WOOLLOOWARE BAY TOWN CENTRE – STAGE 4 CONCEPT PLAN MP10_0229 MOD 2 & PROJECT APPROVAL MP10_0230 MOD 6

Following the completion of the public notification period of the Response to Submissions/ Preferred Project Report for the Stage 4 modification proposal at Woollooware Bay Town Centre (Concept Plan MP10_0229 MOD 2 and Project Approval MP10_0230 MOD 6), Bluestone Capital Ventures No.1 (the Proponent) and the project team have reviewed the matters raised in submissions and provide the following responses.

Drawing Title
Elevations
North & South Elevations

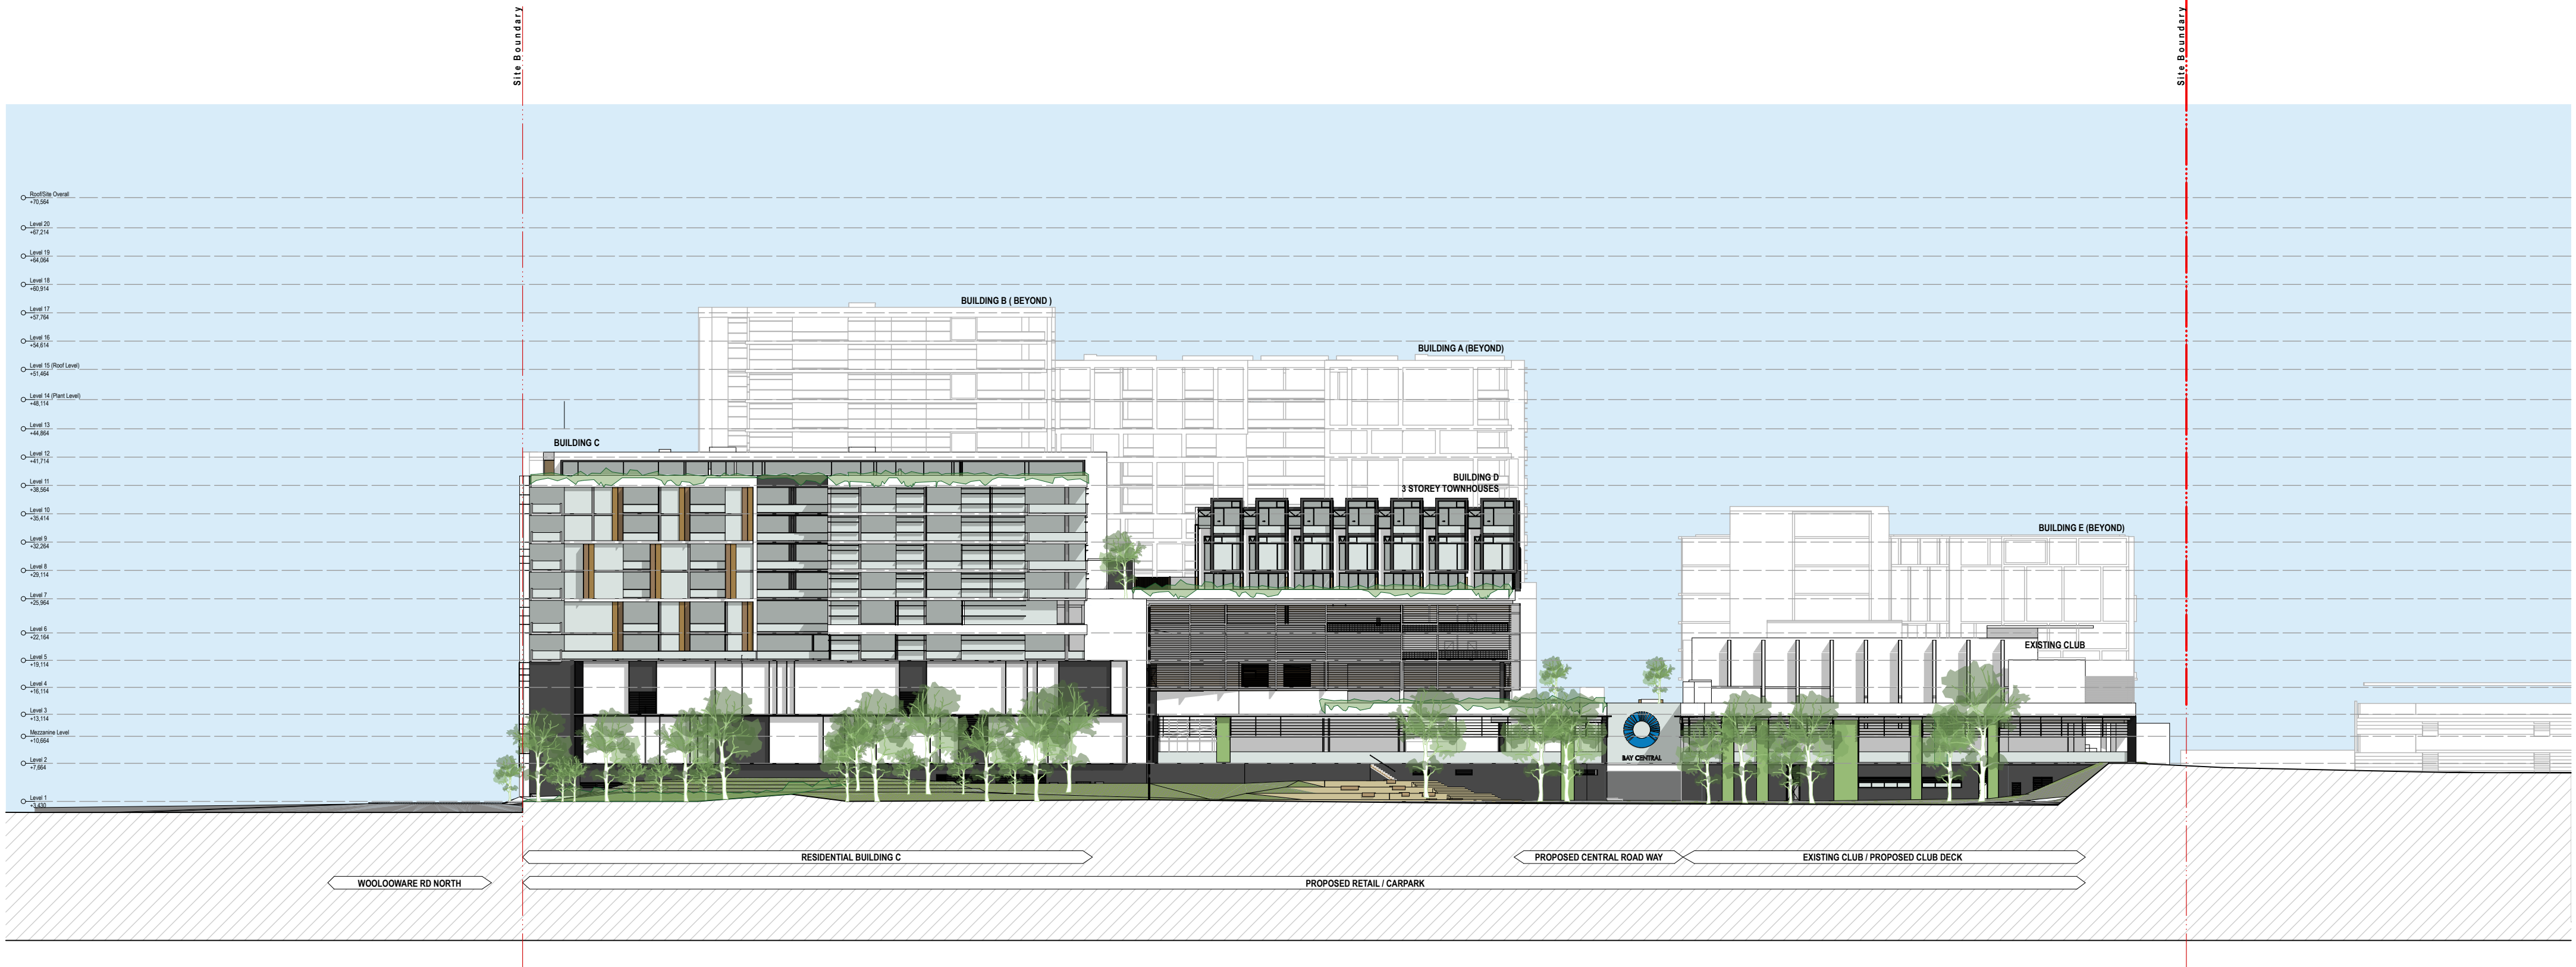
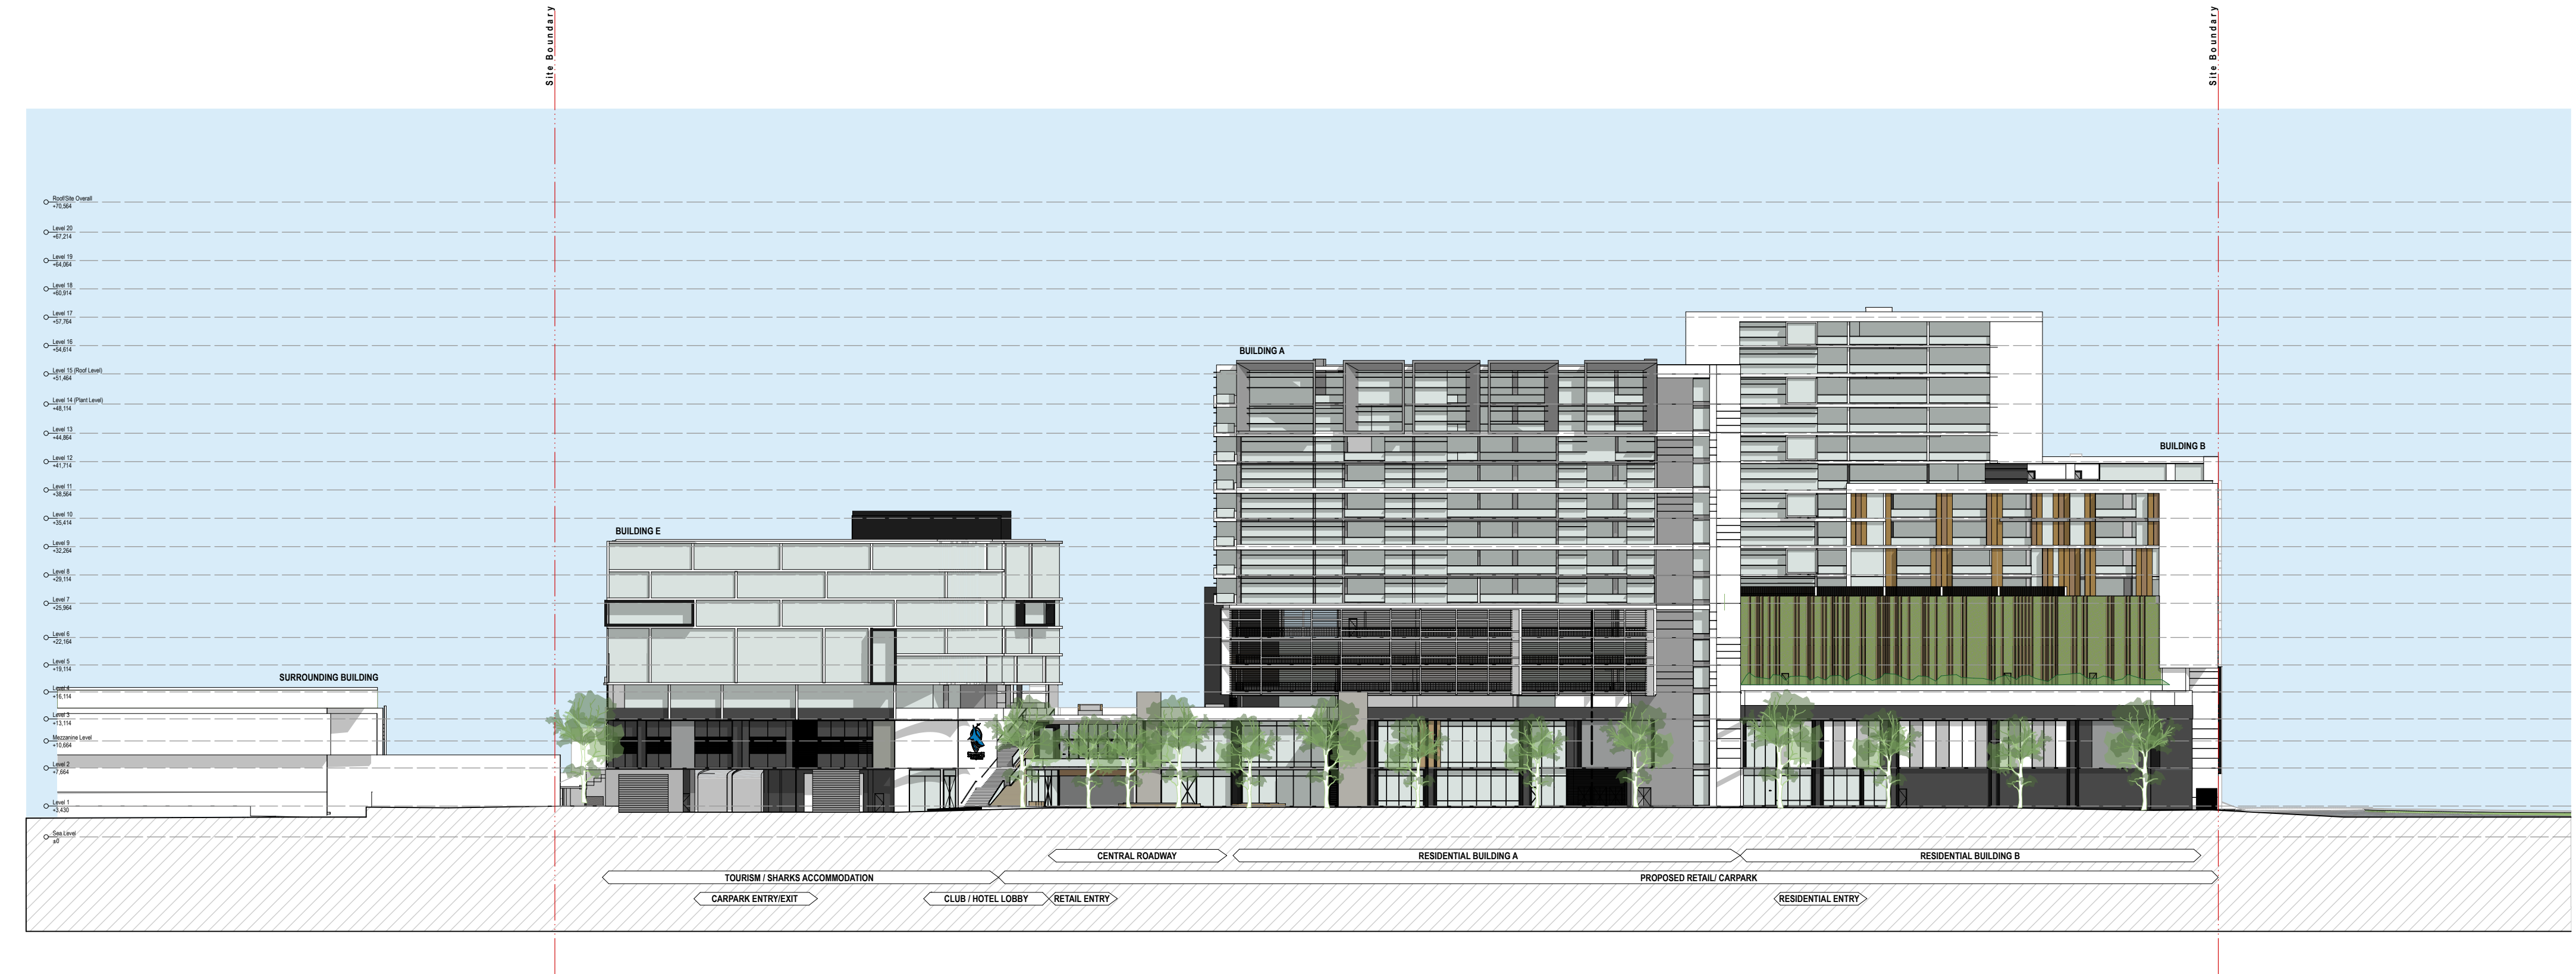
Department query	Proponent’s Response
Confirm the proposed height of the community room (in RL and indicative storeys), as this appears inconsistent in the concept plan and indicative drawings	<p>The proposed community facility would be one storey in height above the podium level, with a small southern element of this structure being two storeys for screening plant and equipment. The Urban Form Control Diagrams (specifically Drawings S6-A-130-009 – extract below – and S6-A-132-011) detail the maximum RL and storeys of this structure and include some tolerance in the maximum height (beyond that shown on the indicative drawings) to allow for detailed design development. We note that the Concept Approval does not currently approve the indicative drawings and it is not proposed to include these in the Concept Plan as part of this Modification Application – they are provided for information only and consent is only sought for the amended Urban Form Control Diagrams.</p>
